Appeal Decision

Appeal Ref: APP/R4408/D/19/3224607
32 Honeywell Place, Barnsley S71 1QB

- The appeal is made under section 78 of the Town and Country Planning Act 1990 as amended against a refusal to grant planning permission.
 - The appeal is made by Mr Mark Whiteley against the decision of Barnsley Metropolitan Borough Council.
 - The application Ref: 2018/1379, dated 26 October 2018, was refused by notice dated 21 December 2018.
 - The development proposed is a detached double garage.
-

PLAN 1:50

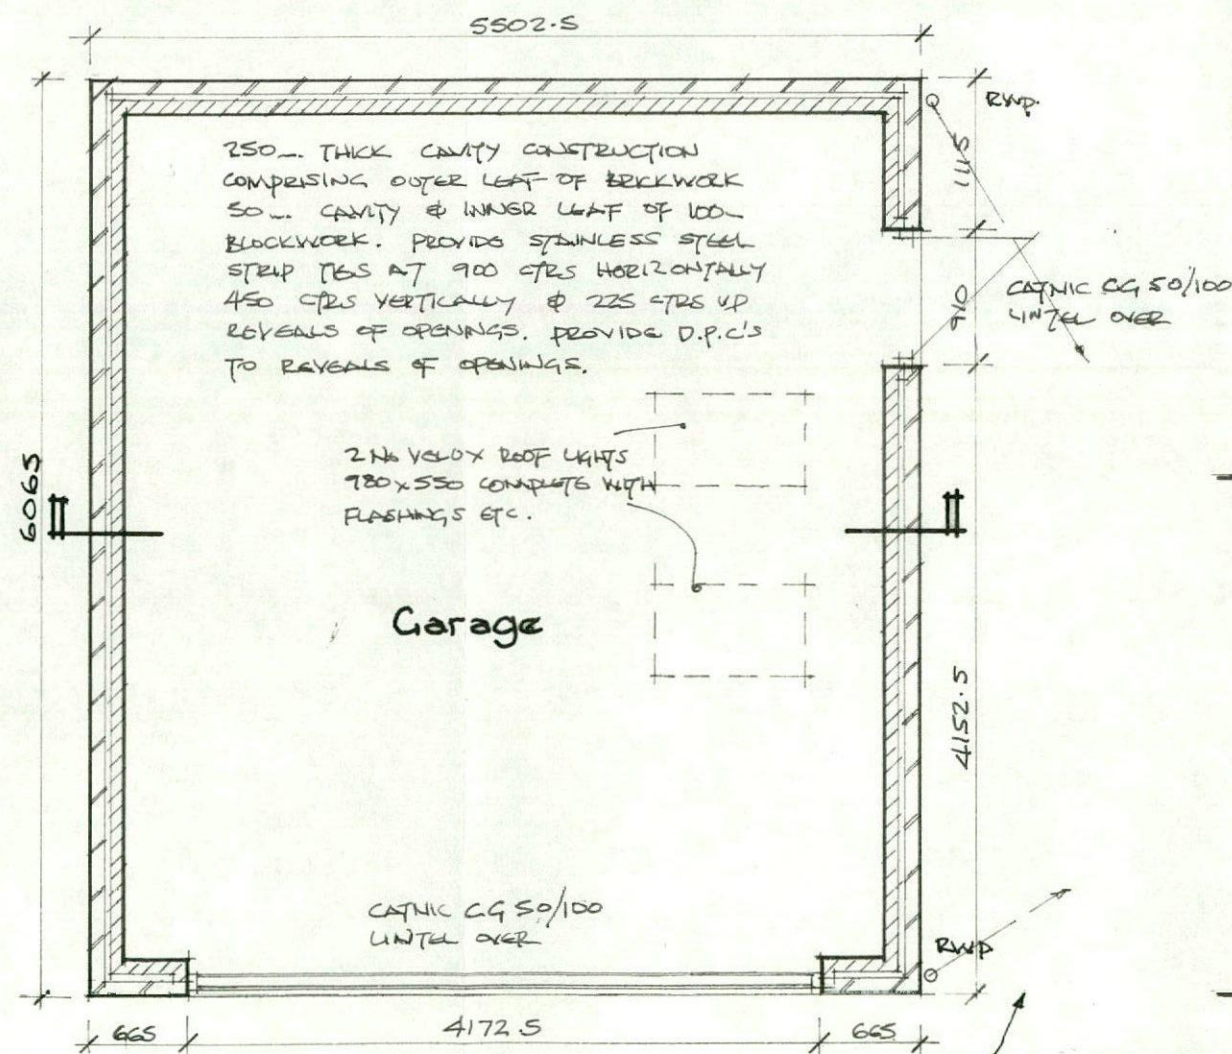
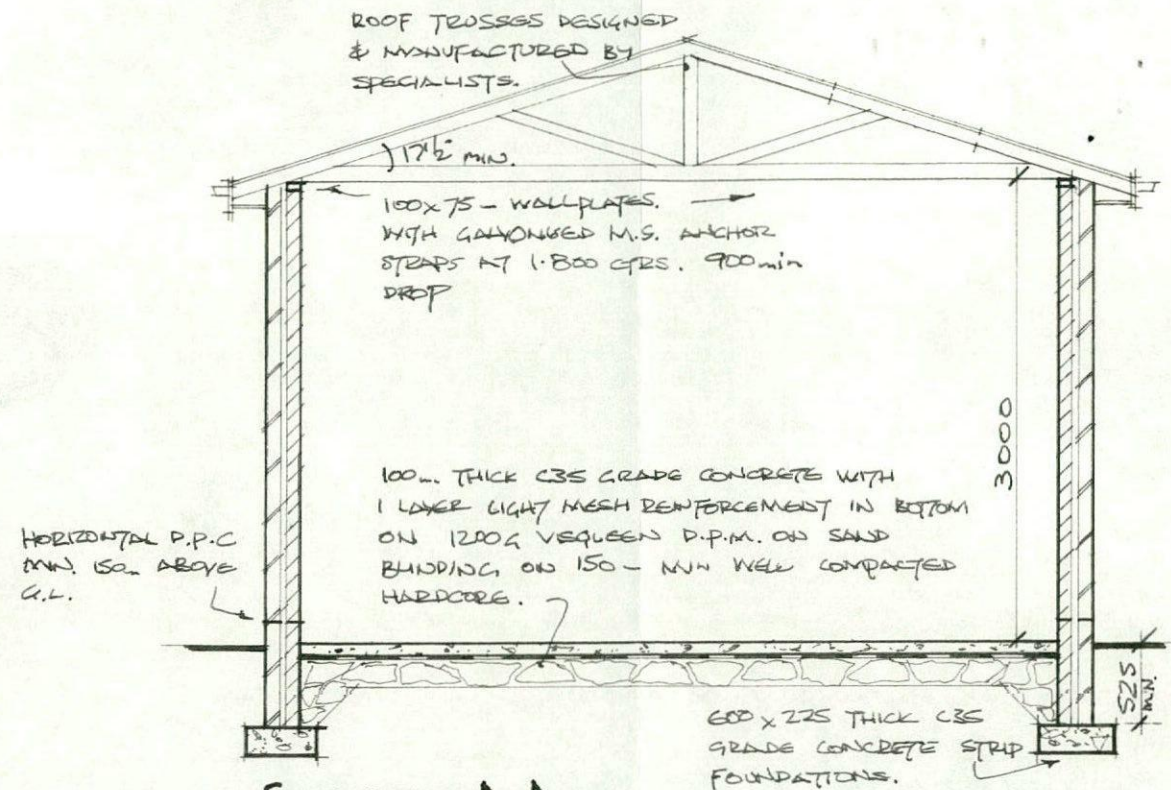
7. Whilst the Proposed Section, Plan and Elevations drawing shows a triangular buffer of land adjoining the east of the garage as part of the dwelling's garden, without the public footpath being illustrated, the footpath exists as described above.

BLOCK PLAN 1/500

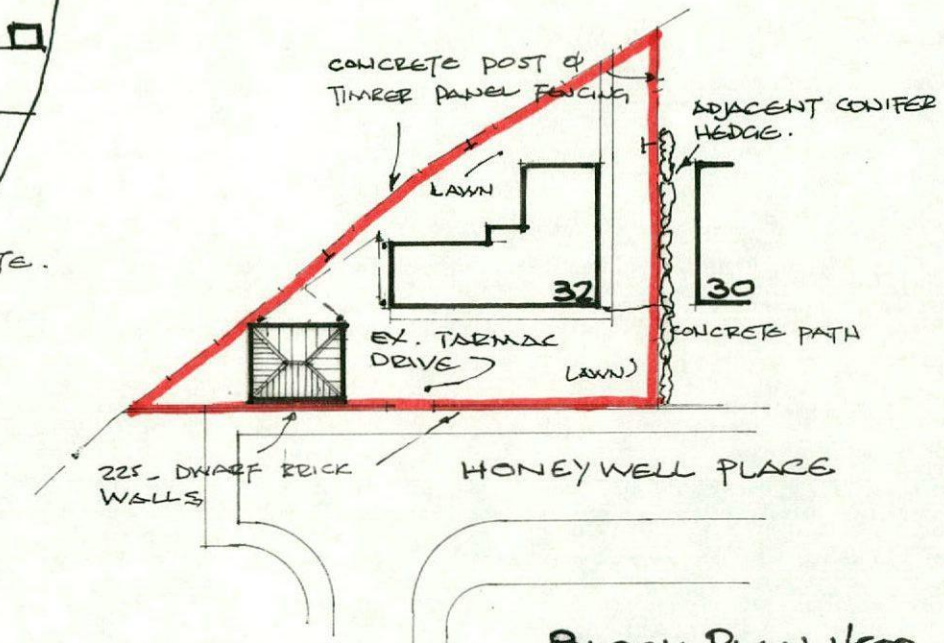
8. The proposed location of blank brick side and rear facades of the garage 'hard up' against the front pavement on Honeywell Place and the entrance to the footpath and cycleway would be visually jarring. The proposal, in combination with the existing tall wall south west of the neighbouring property's garage, would result in a visually discordant 'pinchpoint' around the entrance to the 'green corridor', looking from the street along Honeywell Place.

SIDE ELEVATION. 1:100

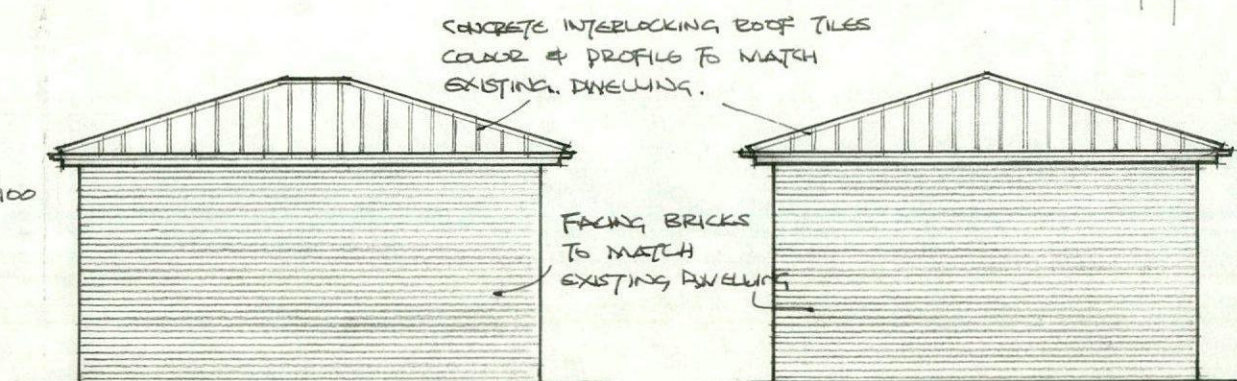
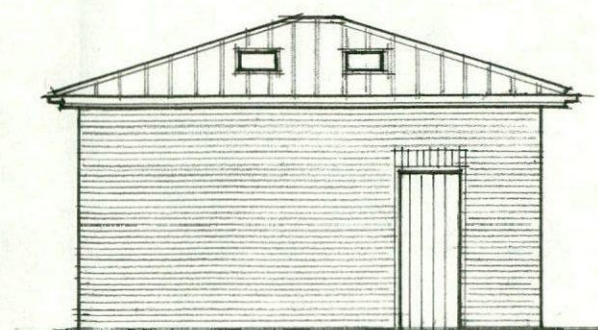
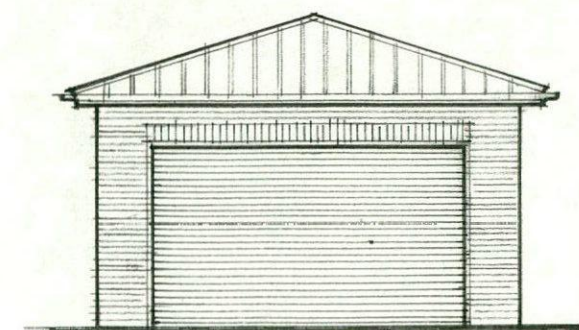
9. The proposed garage's proximity to the front boundary of the appeal site would offer little opportunity for screen planting. Moreover, the proposal's location forward of the front building line of the host bungalow, and the garage's blank side facade adjoining the pavement, would, together, have a visually intrusive effect on the streetscene, including the vista to the green corridor beyond.
